**TOWN AND COUNTRY PLANNING ACT 1990 (AS AMENDED)
SECTION 96A (NON-MATERIAL AMENDMENT) APPLICATION TO PLANNING PERMISSION
REF: 2025/62/92598/E FOR MINOR AMENDMENTS TO FLOOR PLANS, ELEVATIONS, SITE
PLAN, AND ELECTRIC VEHICLE CHARGING CONDITION
CO-OP ACADEMY SMITHIES MOOR, LEEDS OLD RD, HECKMONDWIKE, WF16 9BB
PLANNING PORTAL REF: PP-15201862**

The application proposes minor changes to the floor plans, elevations and site plan, as well as to the electric vehicle charging condition (Condition 13), as approved by planning permission ref: 2025/62/92598/E.

Planning GA Level 00

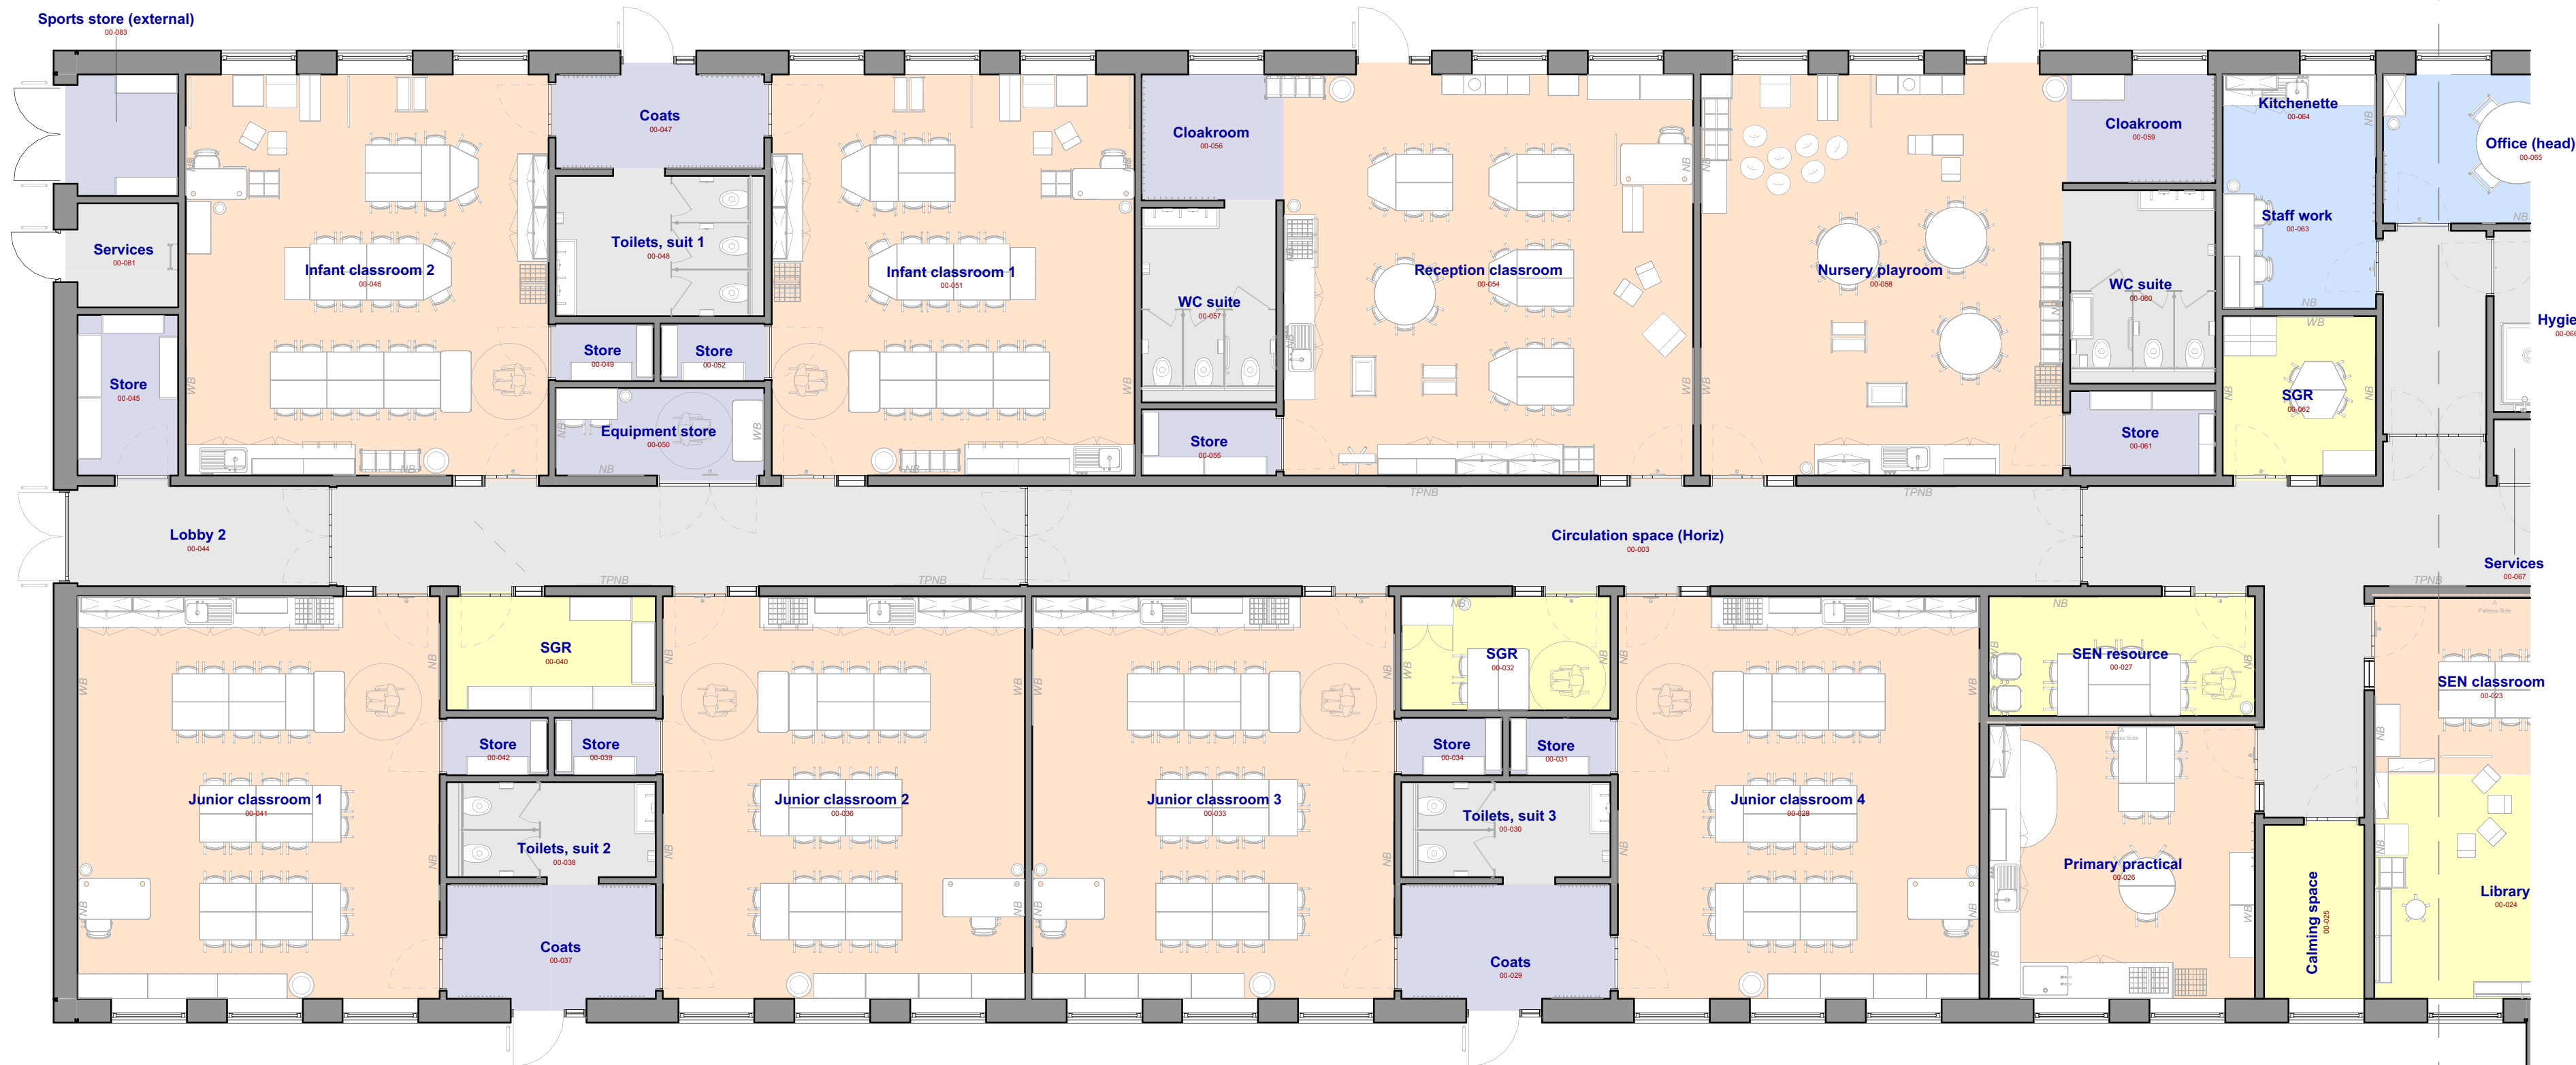
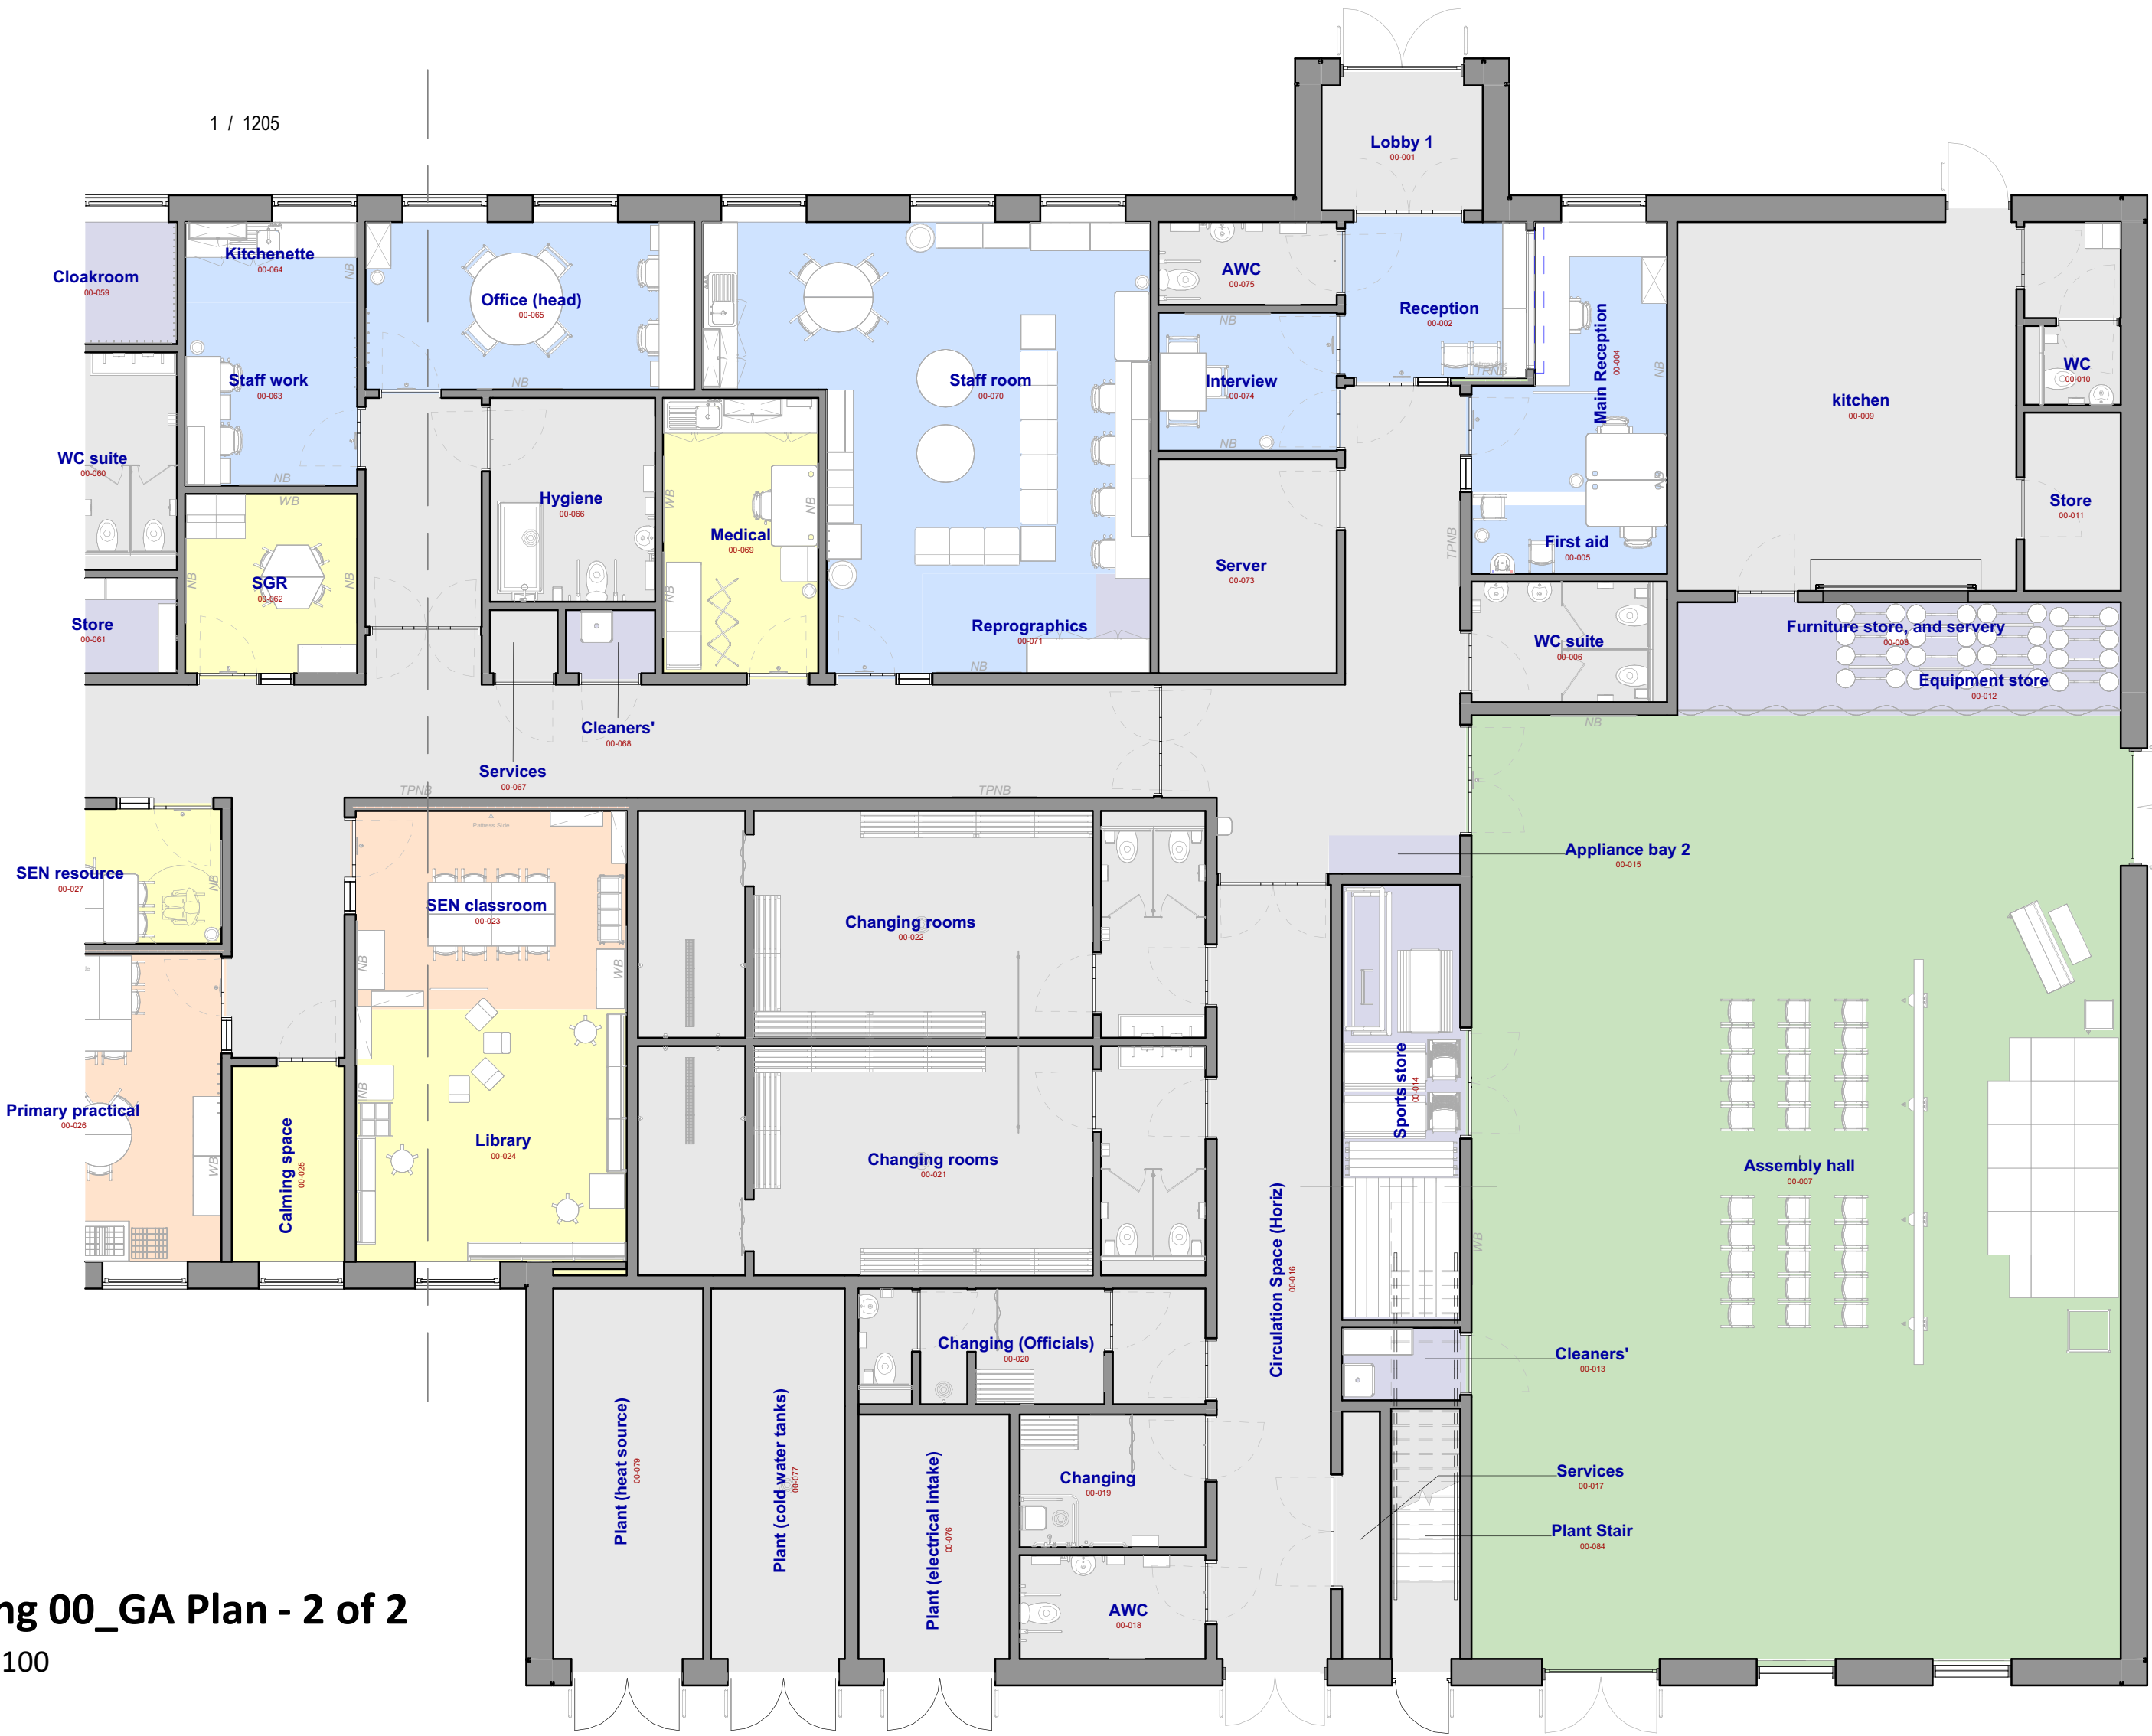
Ground Floor Plan: Changes to the internal floor plan reflecting minor design refinements agreed with the school to improve the building's functionality, storage provision, circulation and supervision arrangements.

Planning Elevations

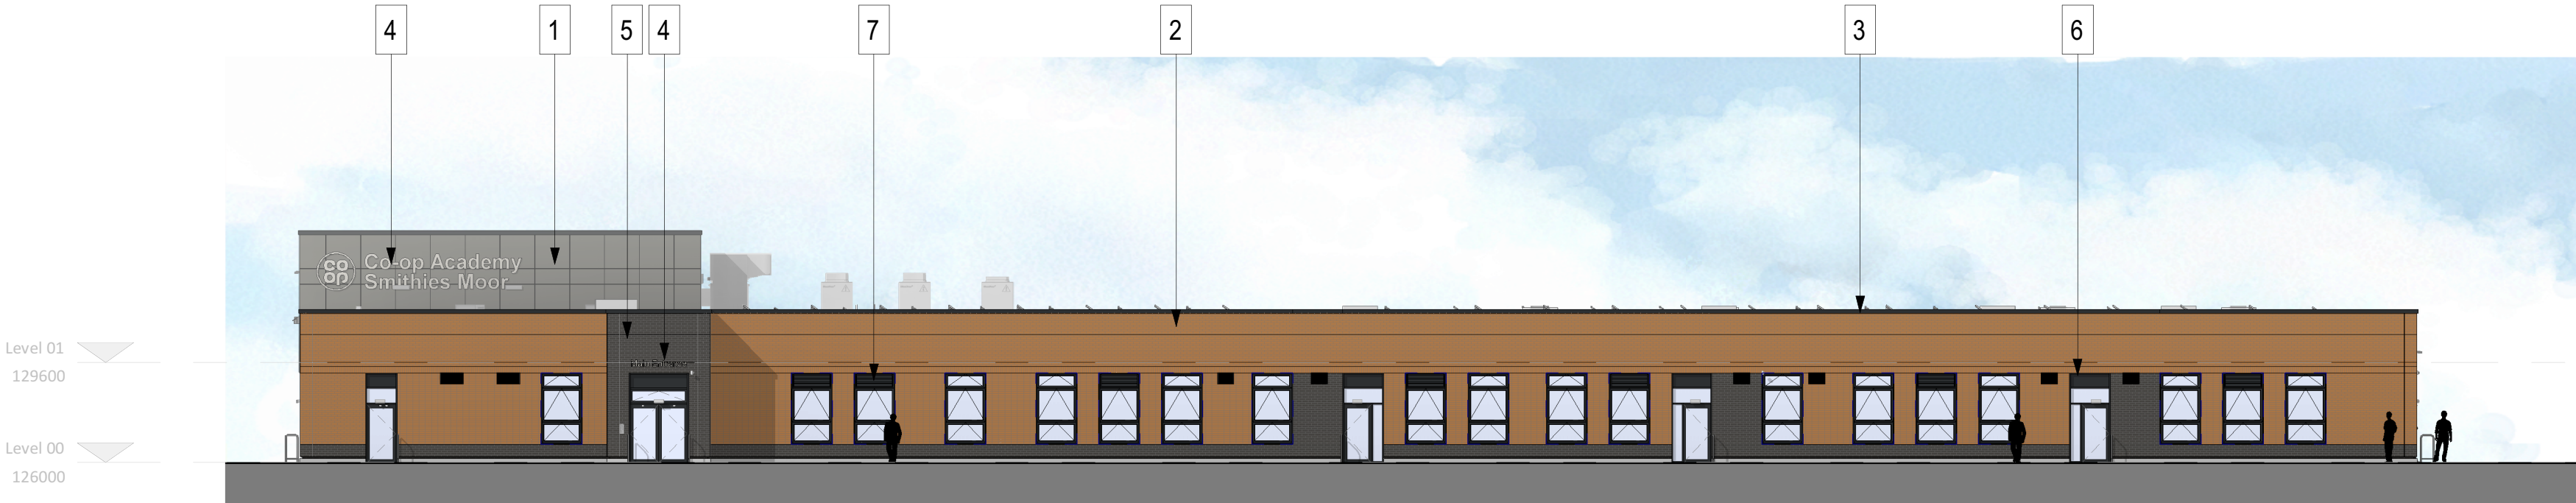
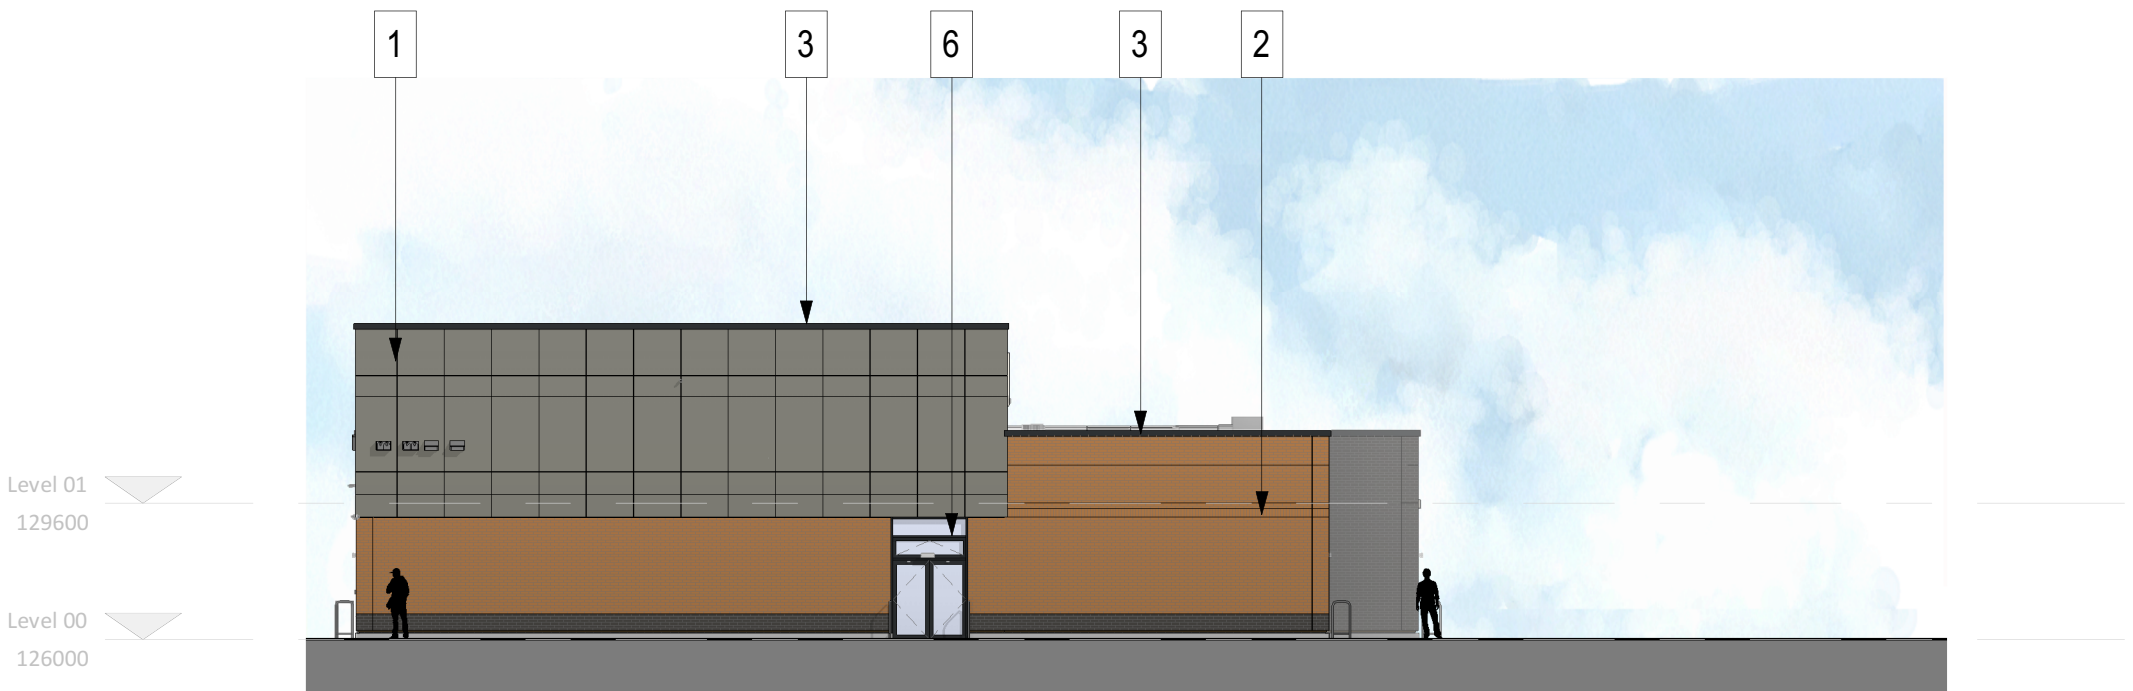
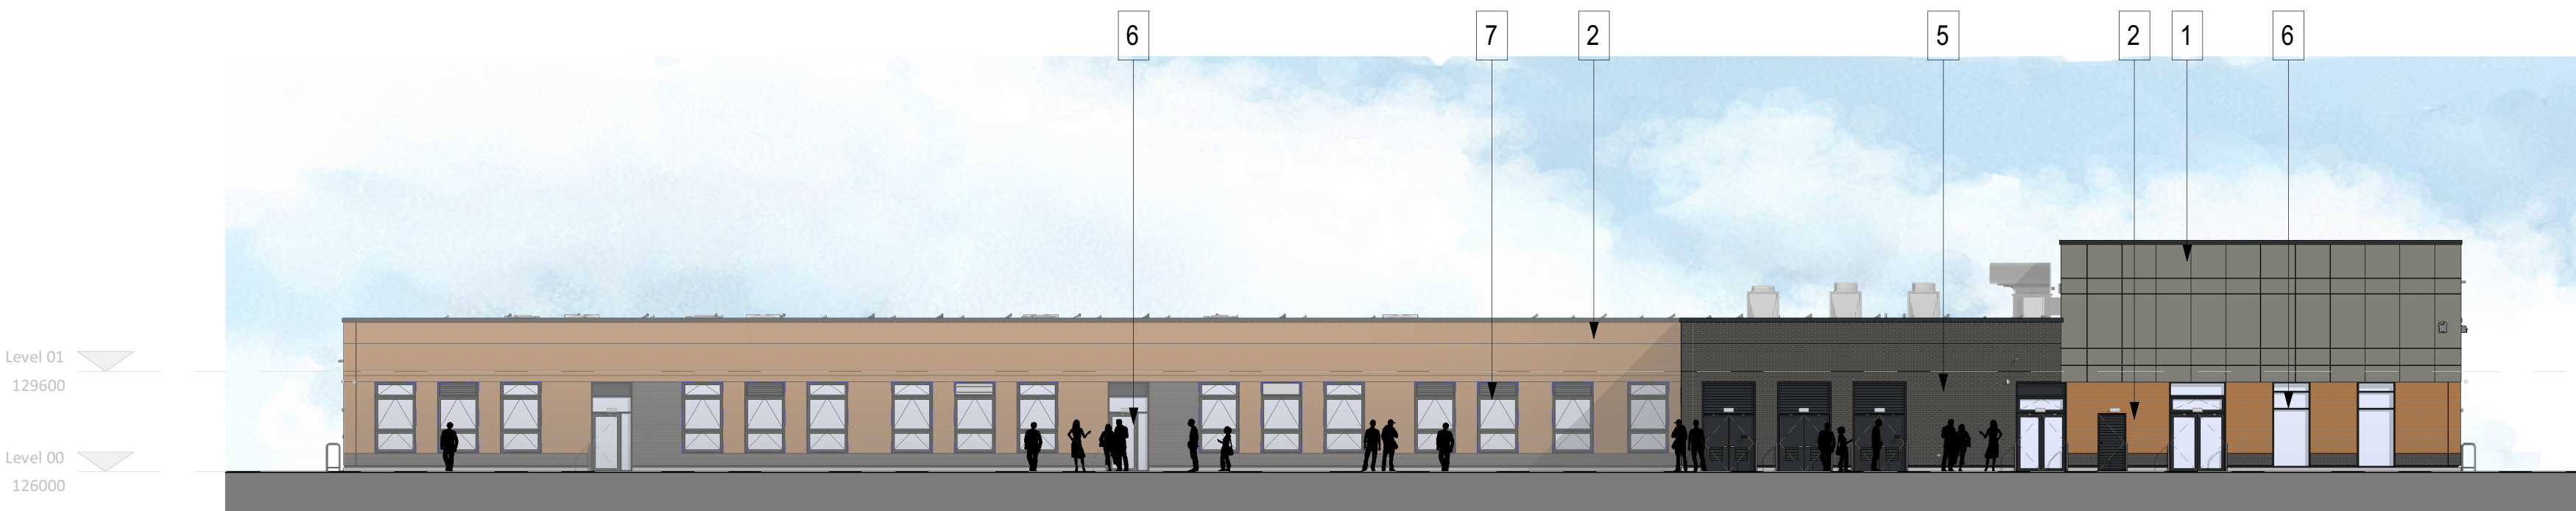
Elevations and Roof Plan: The elevations and roof plan have been updated to reflect the final detailed design of the approved development. This includes the confirmed location of rooftop MEP equipment, approved external materials, bird and bat boxes and minor refinements to brick coursing details around building corners.

The rooftop MEP equipment was shown indicatively on the approved drawings and is now shown in its confirmed form and location for completeness. Similarly, the external materials and the provision of bird and bat boxes have been updated to reflect the details approved by discharge of condition application 2026/90790 and the approved Biodiversity Enhancement Plan.

The brick coursing has also been amended locally at the building corners because the specified construction system does not allow the stack-bonded arrangement to continue around corner details. Stretcher bond is therefore proposed only on the sections of brickwork that wrap around the corners.
